Light Valley Solar

The Applicant's Response to Relevant Representations (Part 1)

September 2026

Planning Inspectorate Reference: EN0110012
The Infrastructure Planning (Examination Procedure) Rules 2010
Rules 8(1)(c)

Drawing Number
EN0110012/APP/LVS/06.02.06.12.05

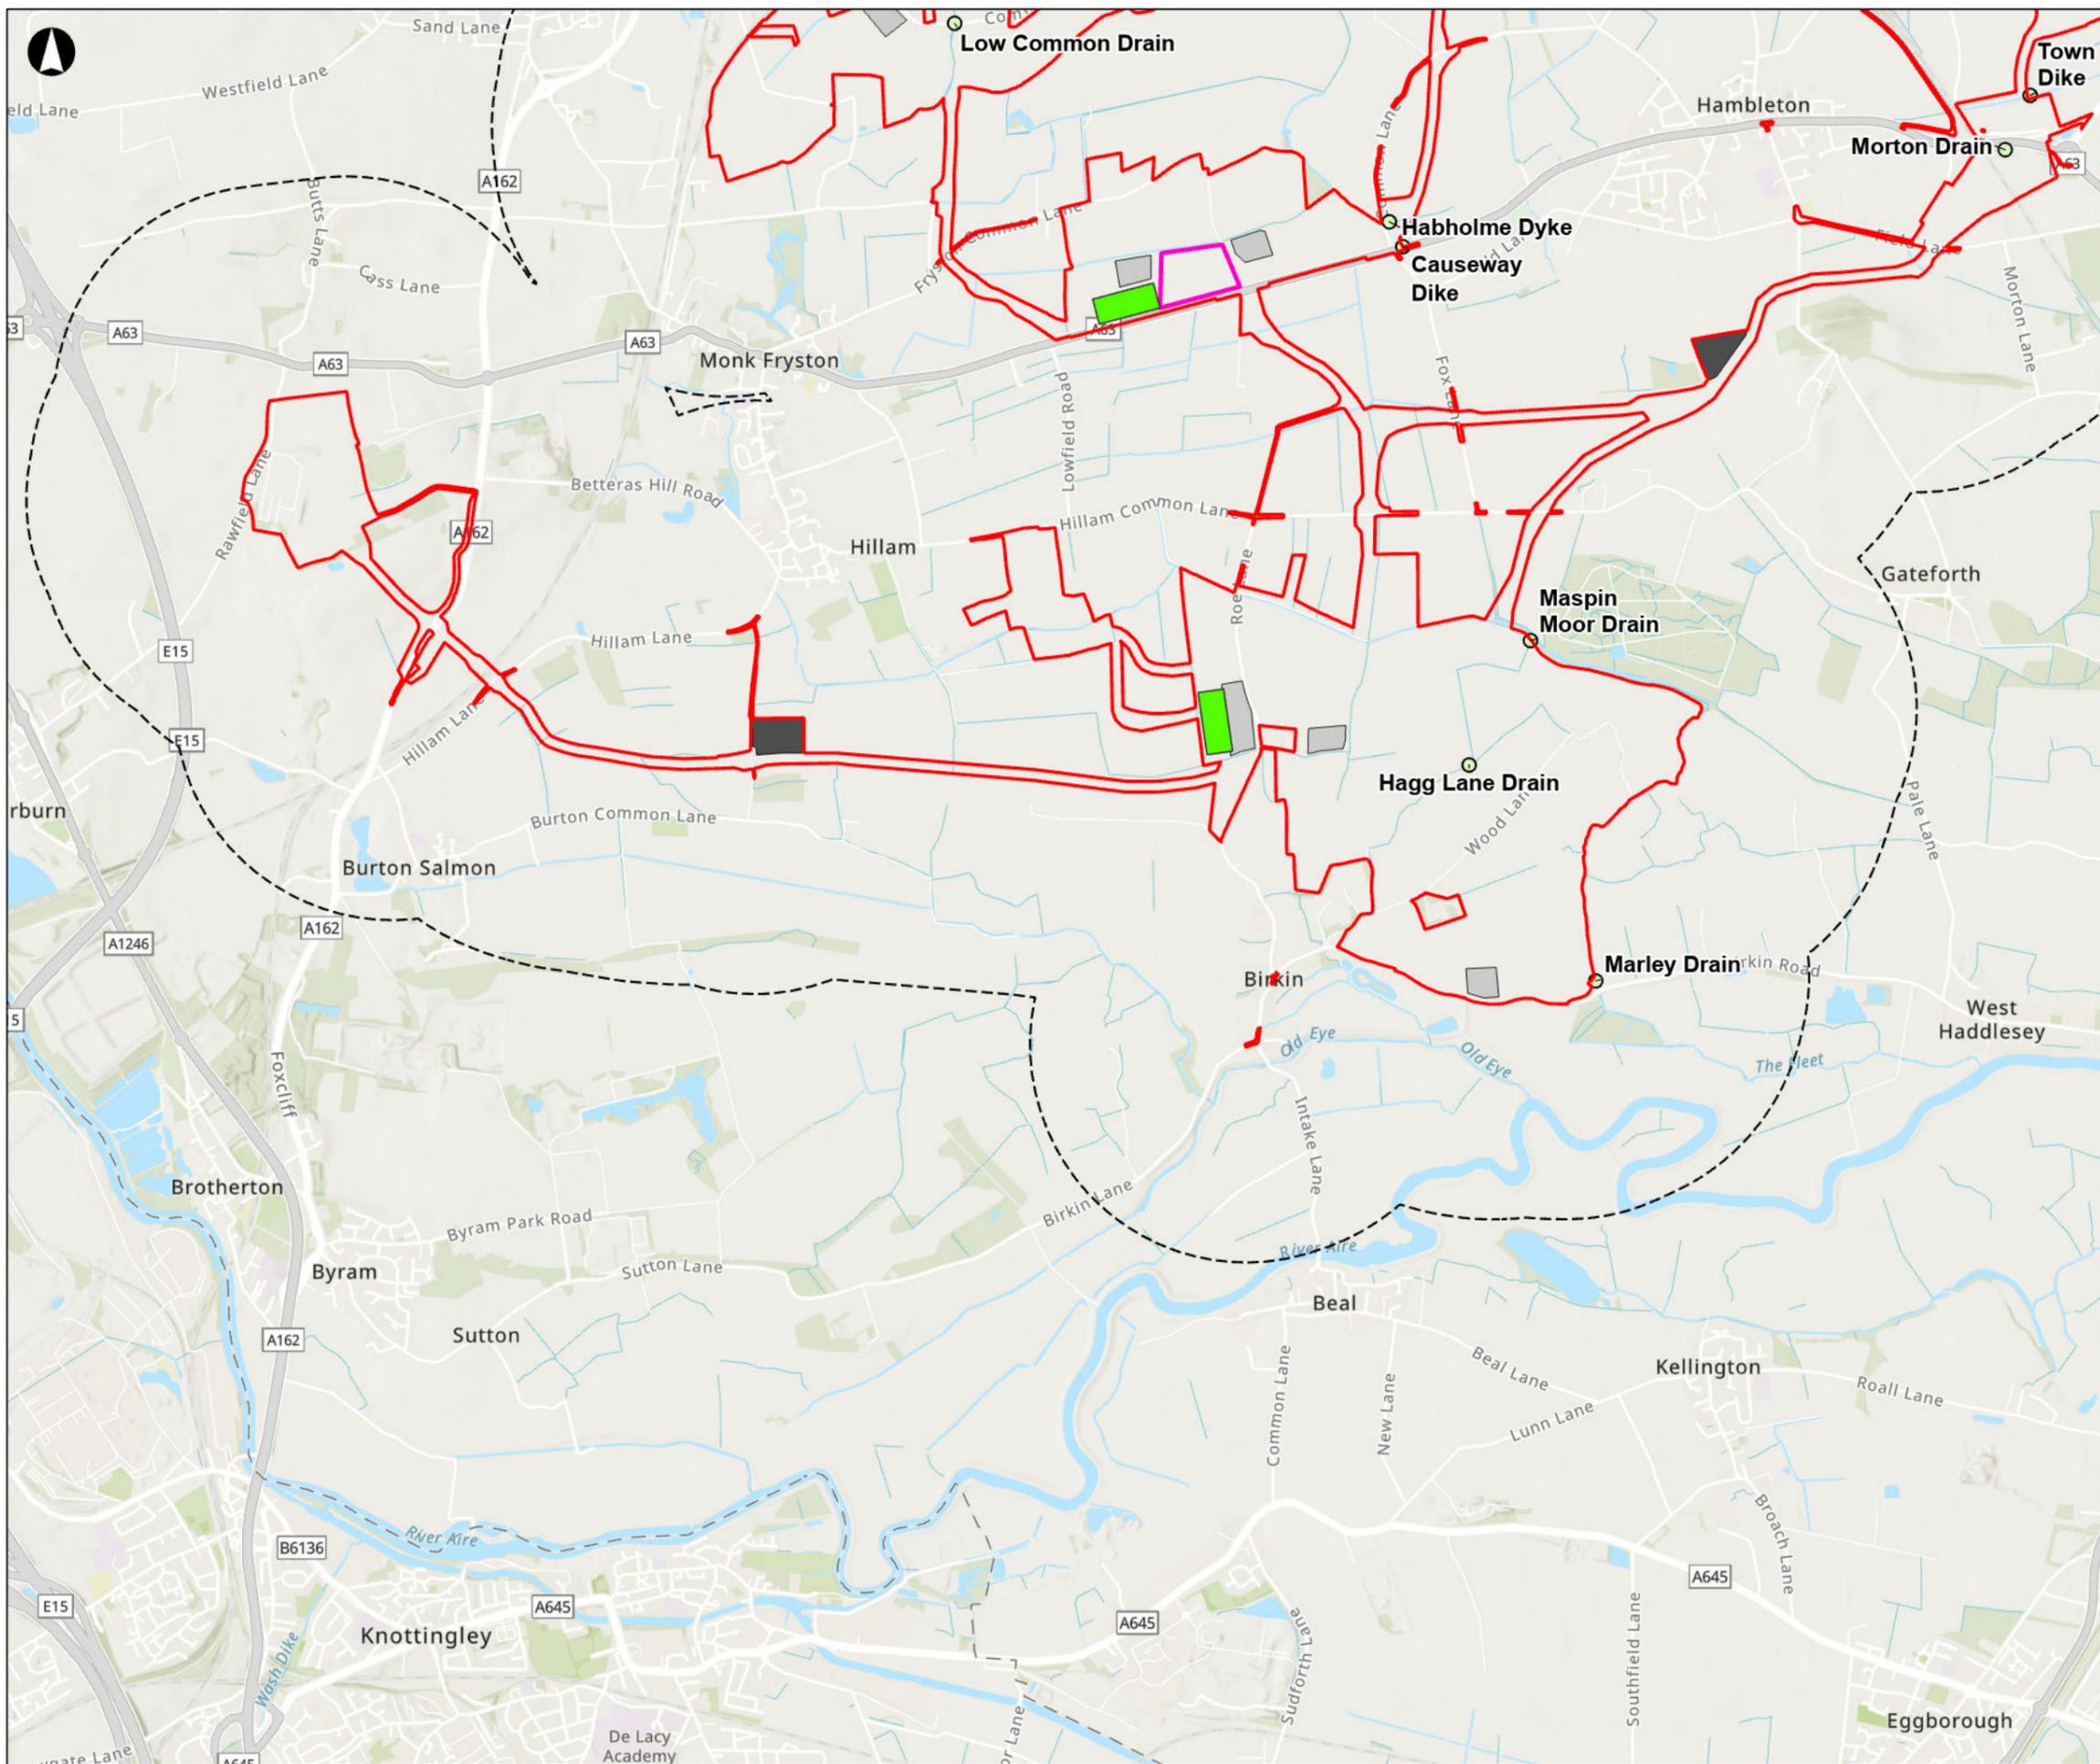
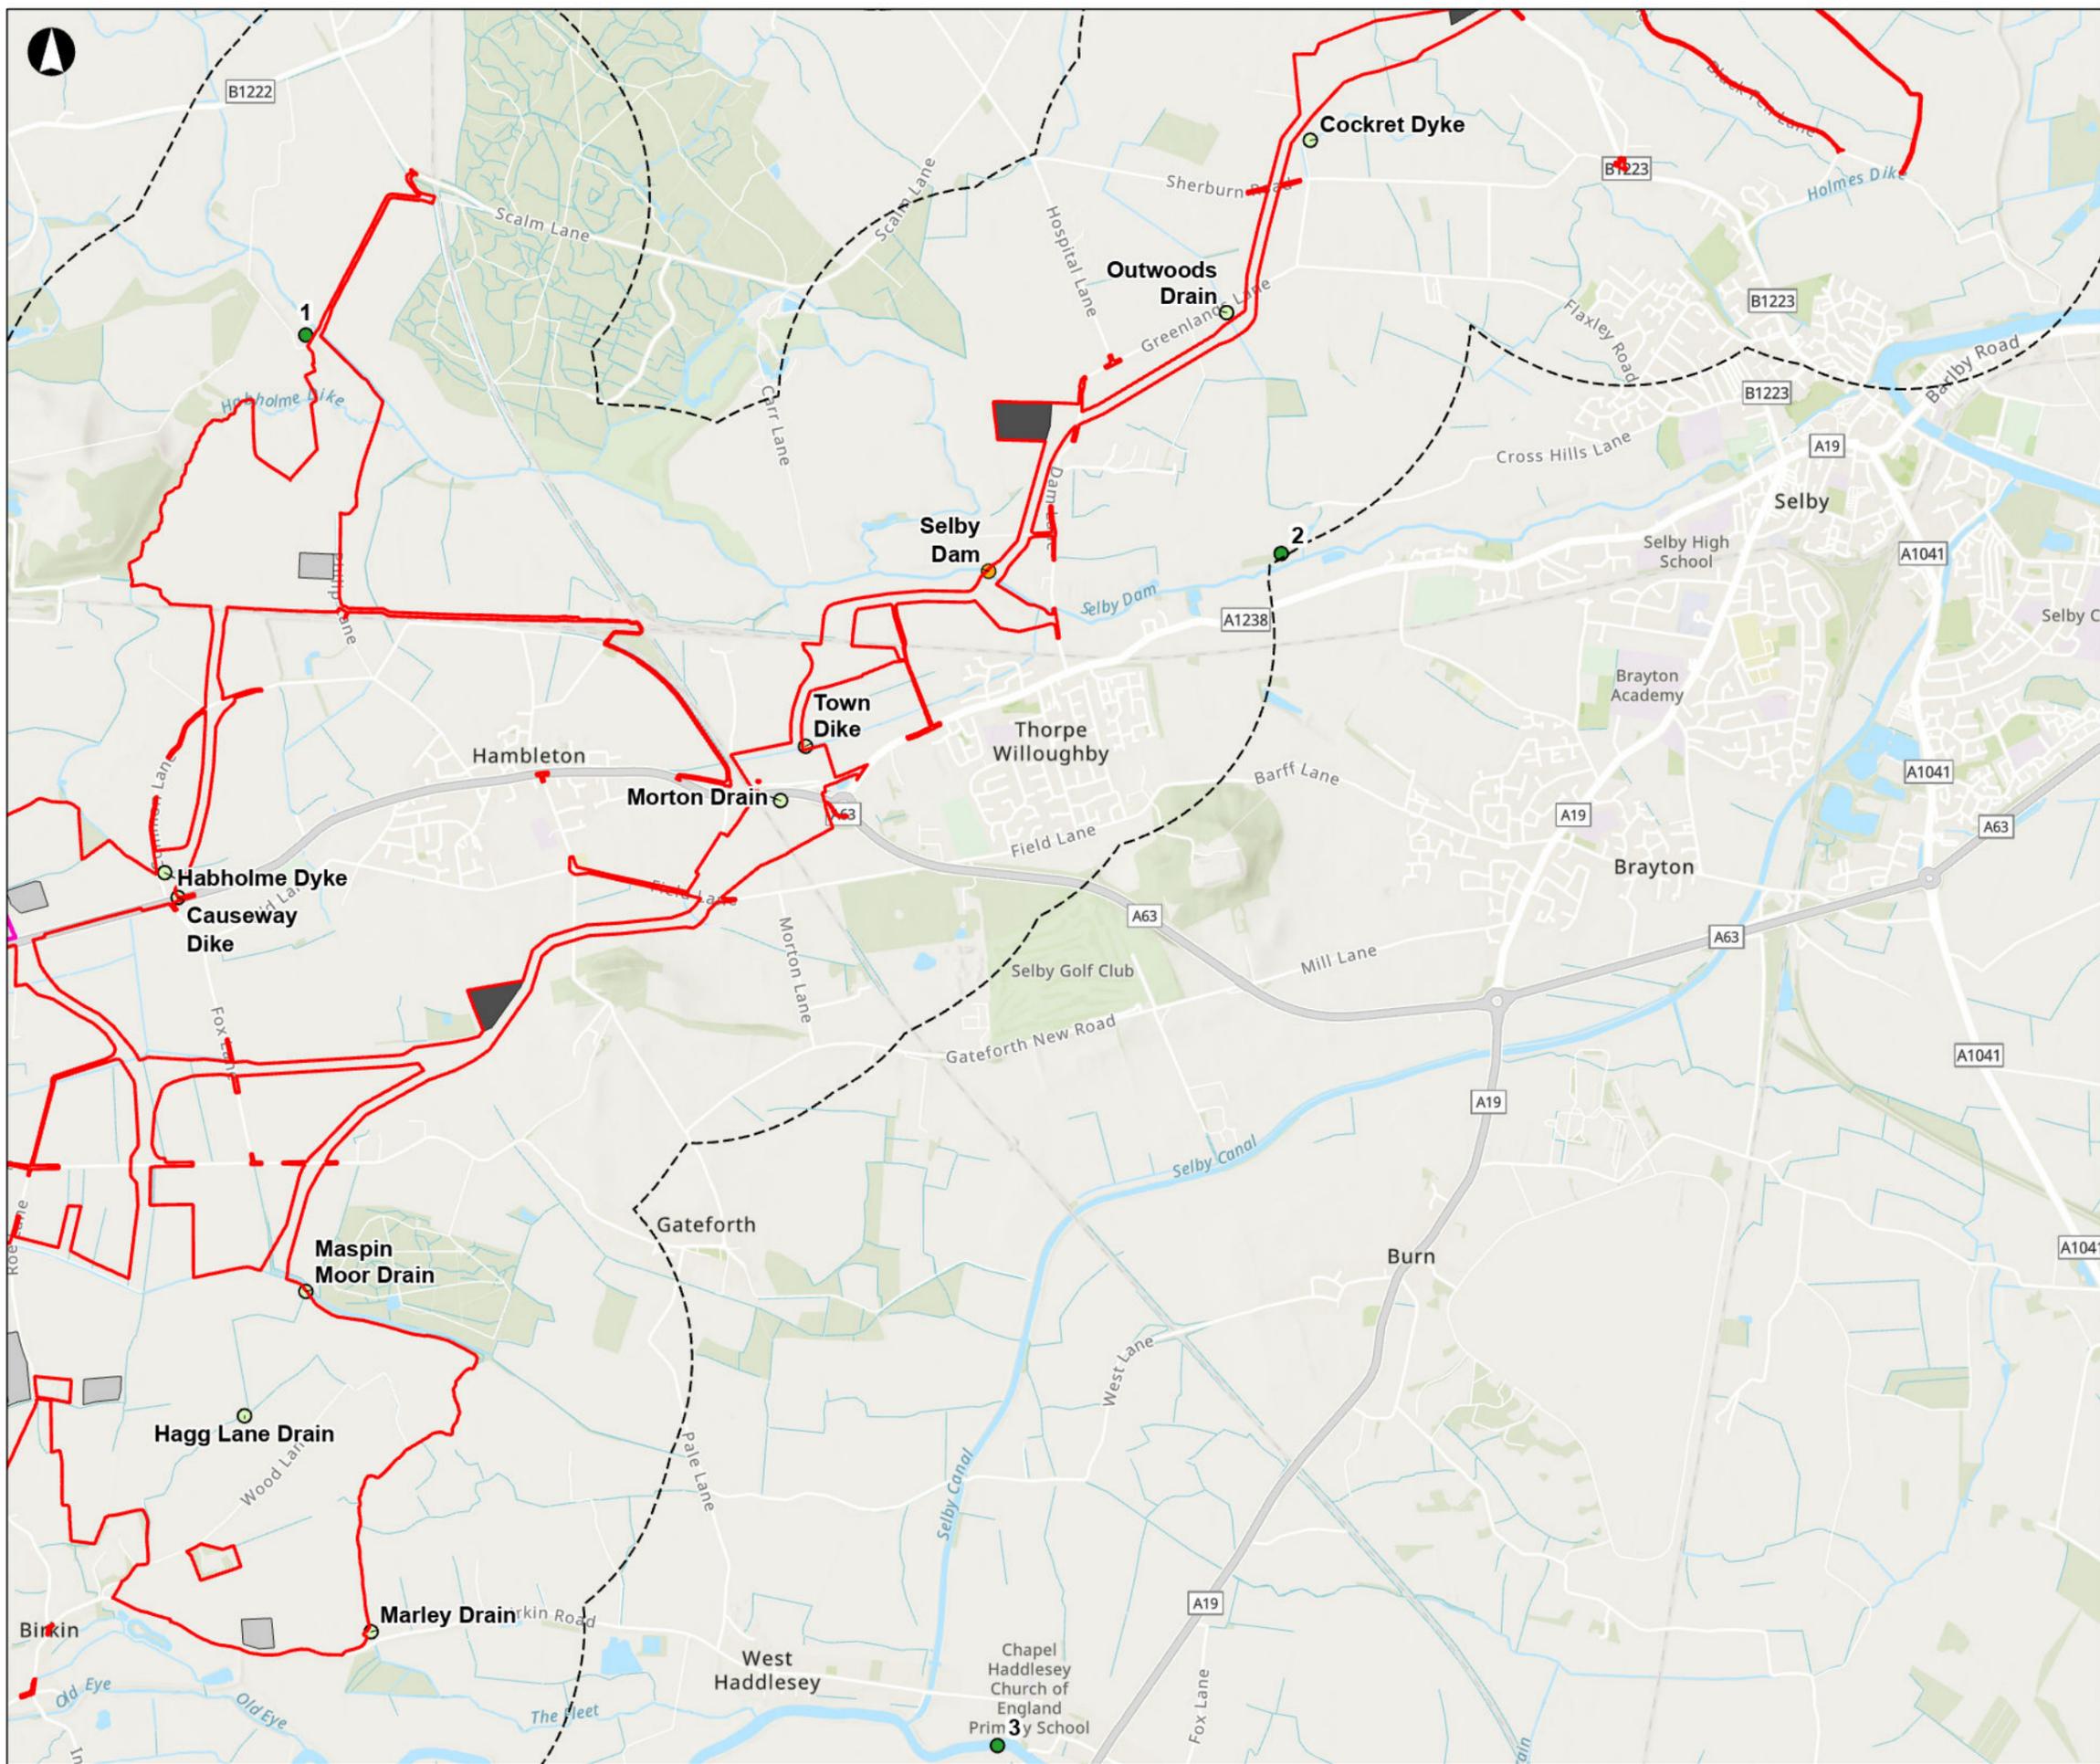
ID	Theme	Issue	Comment			Applicant's Response
EA02	Biodiversity and Ecology	Fish eDNA Survey	Appendix 6.5 Fish Habitat Assessment and eDNA Survey (Aquatics Report) [APP-155], Sections 3.2.20 to 3.2.26, Table 2-2	Issue:	The fish habitat assessment concludes that the Hagg Lane Drain and Mearley Drain are unsuitable for fish and have therefore been scoped out of the eDNA survey. It has not been clearly demonstrated that this is an acceptable approach.	eDNA sampling was targeted at watercourse crossings where impacts could occur, as agreed during consultation with the EA (04 March 2025). Mearley Drain is not crossed by the Proposed Development and impacts will be avoided through a 10 m buffer within Solar Development Site 4. Hagg Lane Drain is crossed by the lower voltage 33kV cable alignment; however, it is envisaged this watercourse will be crossed using an existing crossing. As no impact pathways to these watercourses are anticipated, the level of baseline data collection and consideration of the

Impact:	It is possible that fish could be present in these watercourses and could be detrimentally impacted.	
				Solution:	The Hagg Lane Drain and Mearley Drain should both be

included in the fish eDNA survey, unless further sufficient evidence can be presented that would support the initial findings of the fish habitat assessment.	desk study position is proportionate to inform the EIA of impacts to these watercourses. The EA will be provided with grid references for each survey location.
			Additional comments:	Where there is an insufficient baseline to inform the Environmental Impact Assessment (EIA), impact-pathways to receptors may not be fully assessed. Whilst we agree that waterbodies that lack water are unsuitable for fish, we do not agree with the conclusion that the Hagg Lane Drain and Mearley Drain are unlikely to support fish due to poor habitat. Both of these waterbodies have hydrological connectivity with the River Aire. While we acknowledge that fish passage for European eel may be hindered by the pumping station on the Mearley Drain, the eDNA results for Selby Dam demonstrate that the presence of a pumping station does not necessarily preclude European eel. It would be useful if Table 2-2 could be updated to include grid references for each survey location. The provision of a map showing the locations would also be welcomed. Both would assist the reader in understanding where surveys have been undertaken in relation to the draft Order Limits.		A figure showing survey locations in relation to the draft Order Limits and project components is already provided as ES Volume 2, Figure 6.12: Fish Habitat Assessment, EA Monitoring Locations and eDNA Survey Locations [APP-083] .
